**State Environmental Planning Policy (Transport and Infrastructure) 2021
State Significant Development Application - SSD-66826207-Mod 1
405 Pacific Highway, 5 Falcon Street & 8 Alexander Street Crows Nest
Request for additional information**

27 June 2025

SHORING WALL SW1
SCALE 1:100

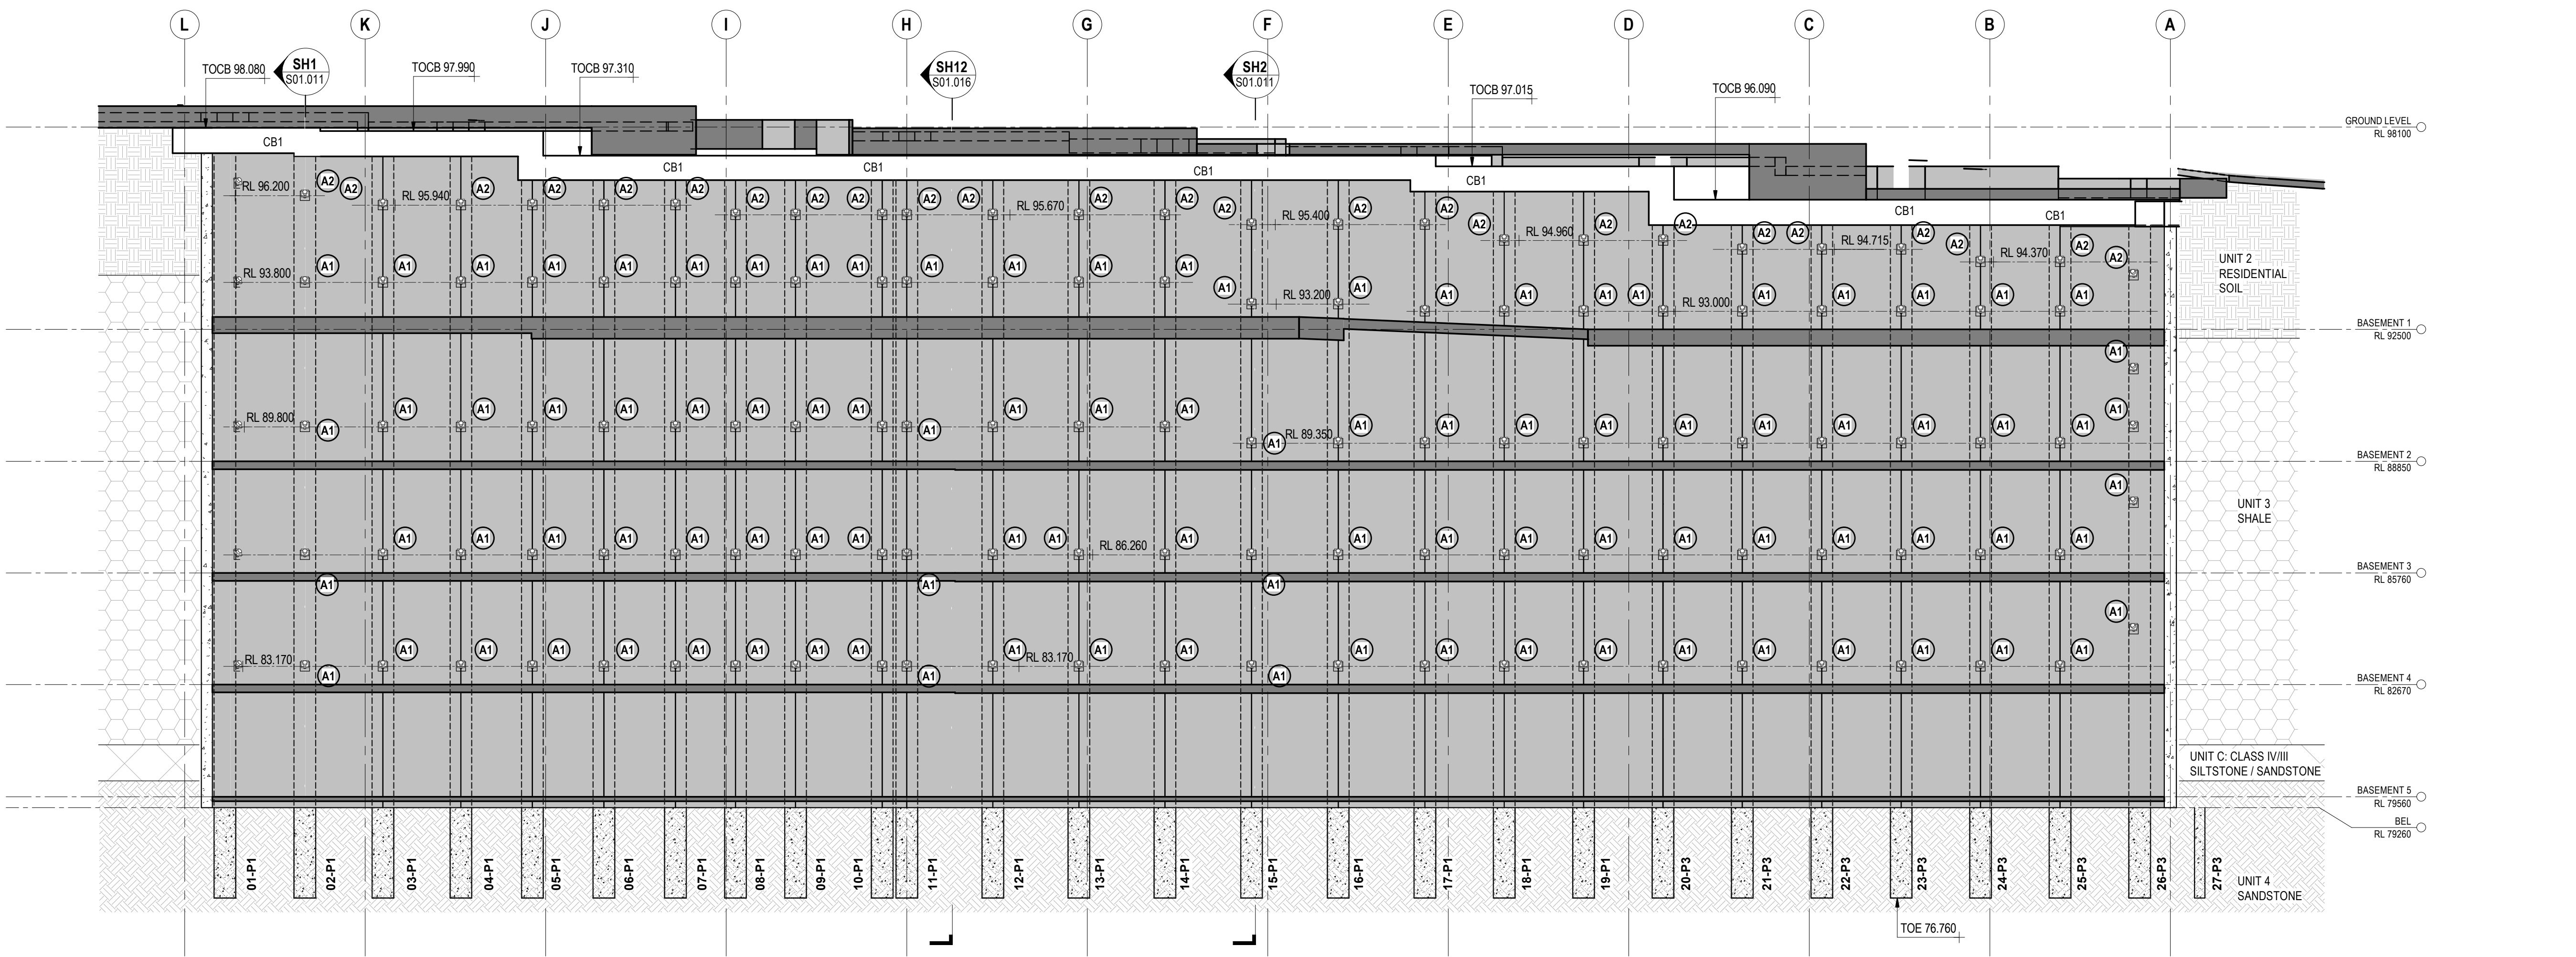
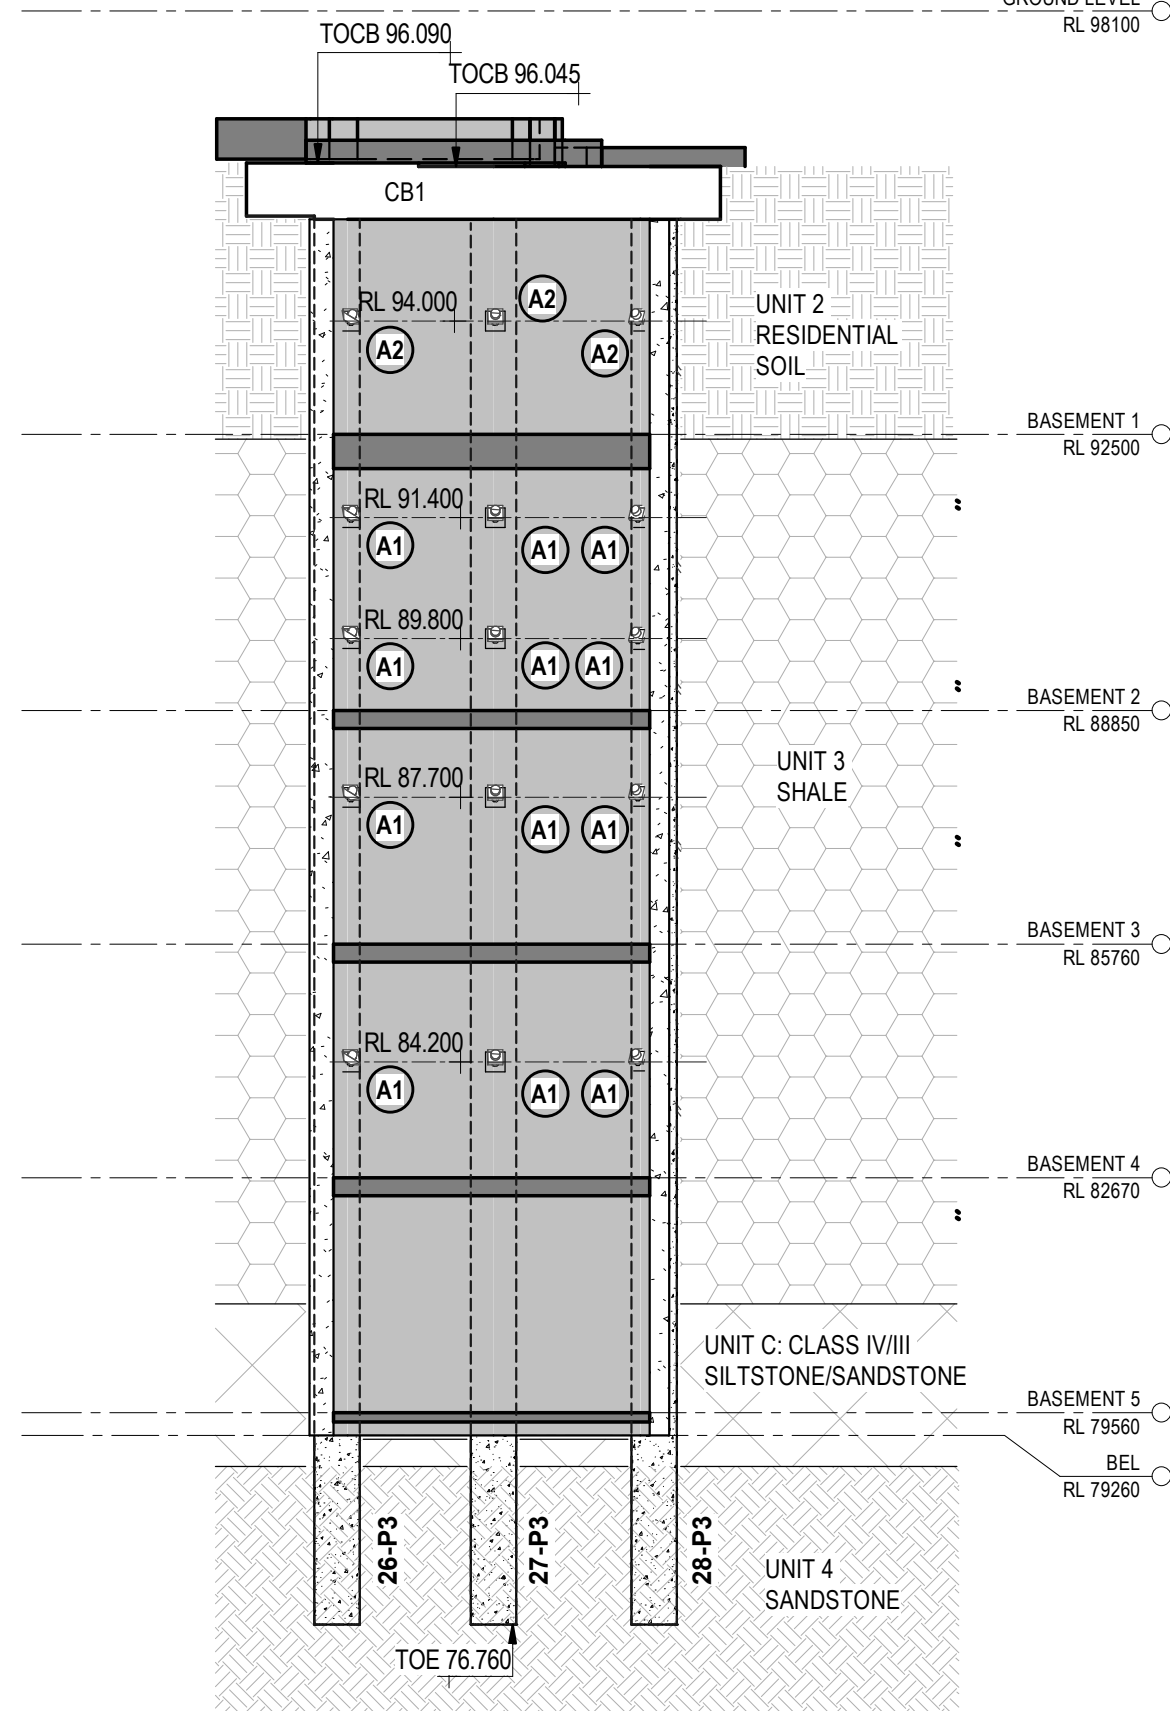
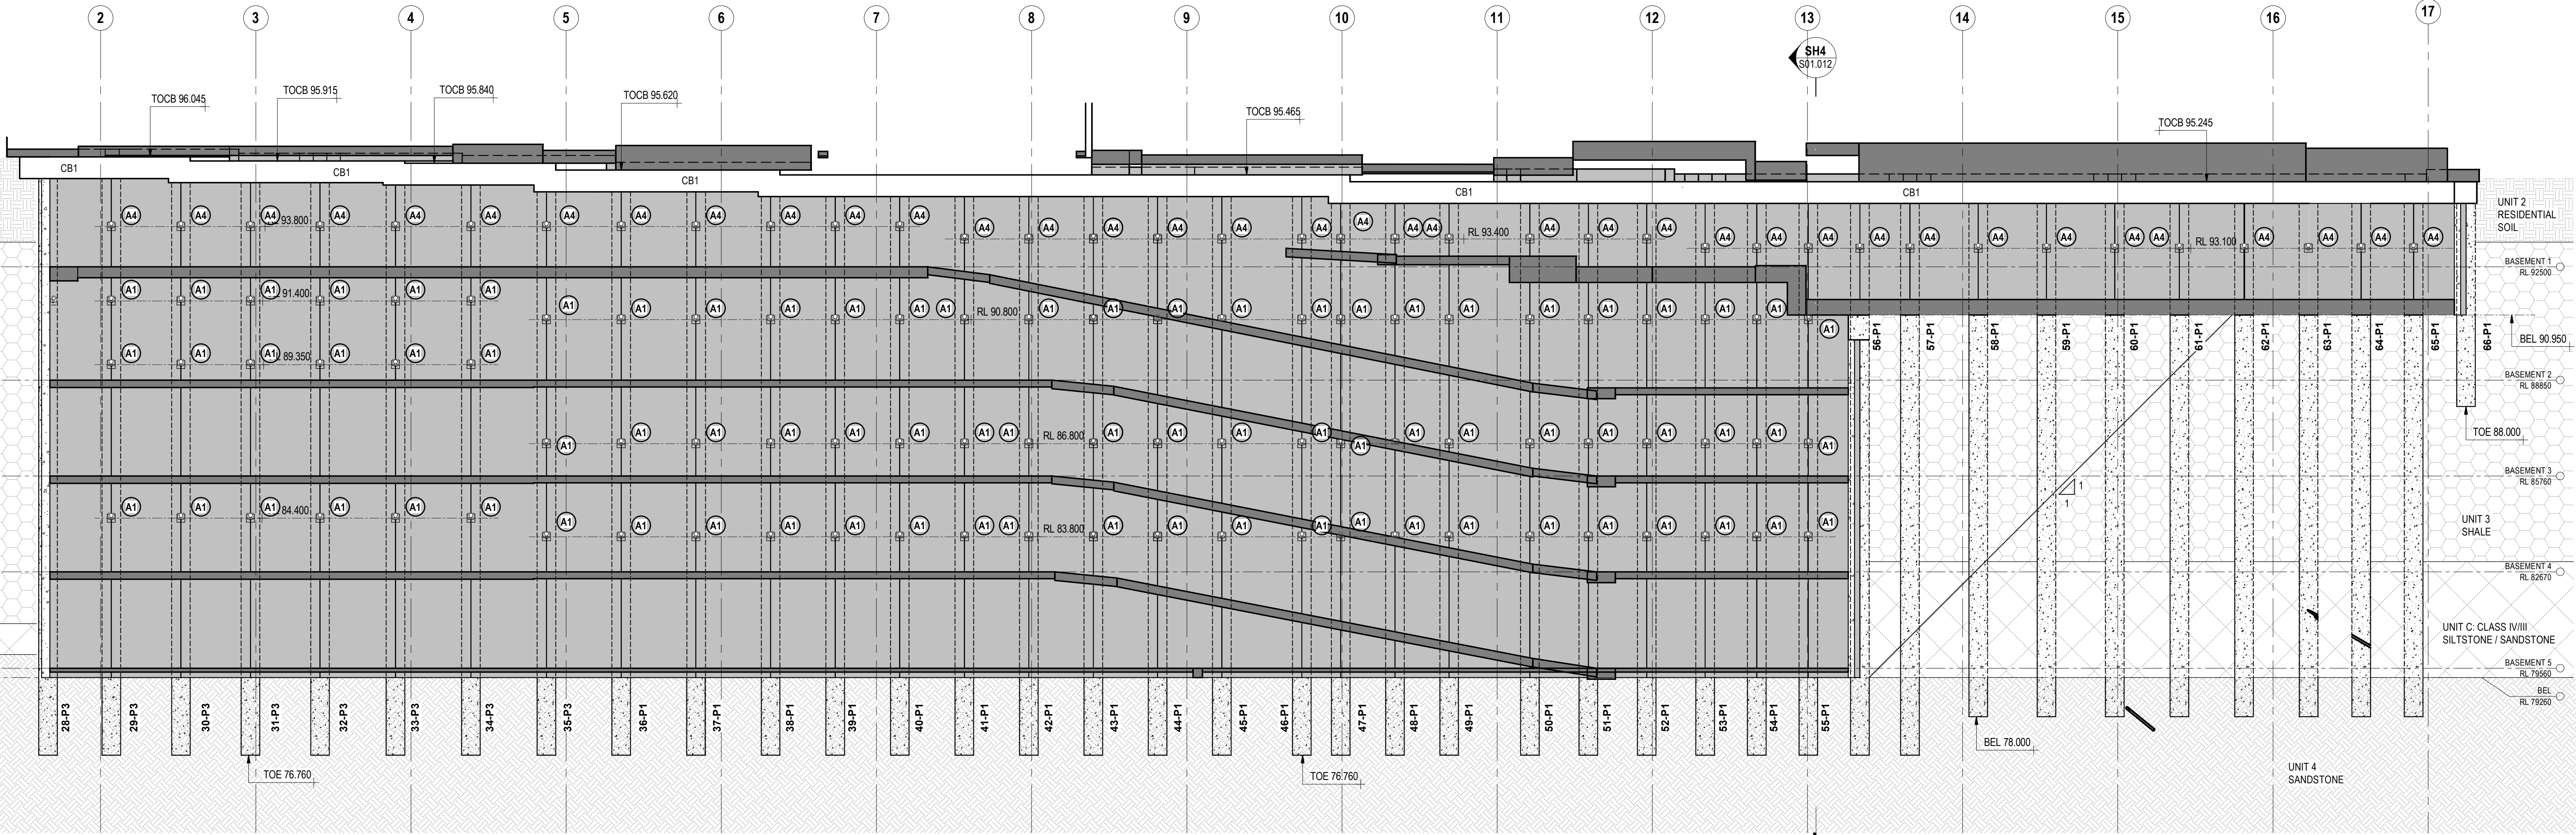
- g) The proposed shoring pile toe level is RL76.760 which is around 3m above the 1st reserve. Please provide an impact assessment of the proposed shoring wall design.
- h) Shoring wall elevation drawings show that P1 to P4 piles but only pile type P1 is listed in Pile Toe Schedule table on drawing S01.001 Rev 05.
- i) Section SH2 shows that anchors to be installed would be below the shoring pile toe level which is in closer proximity to the 1st reserve.
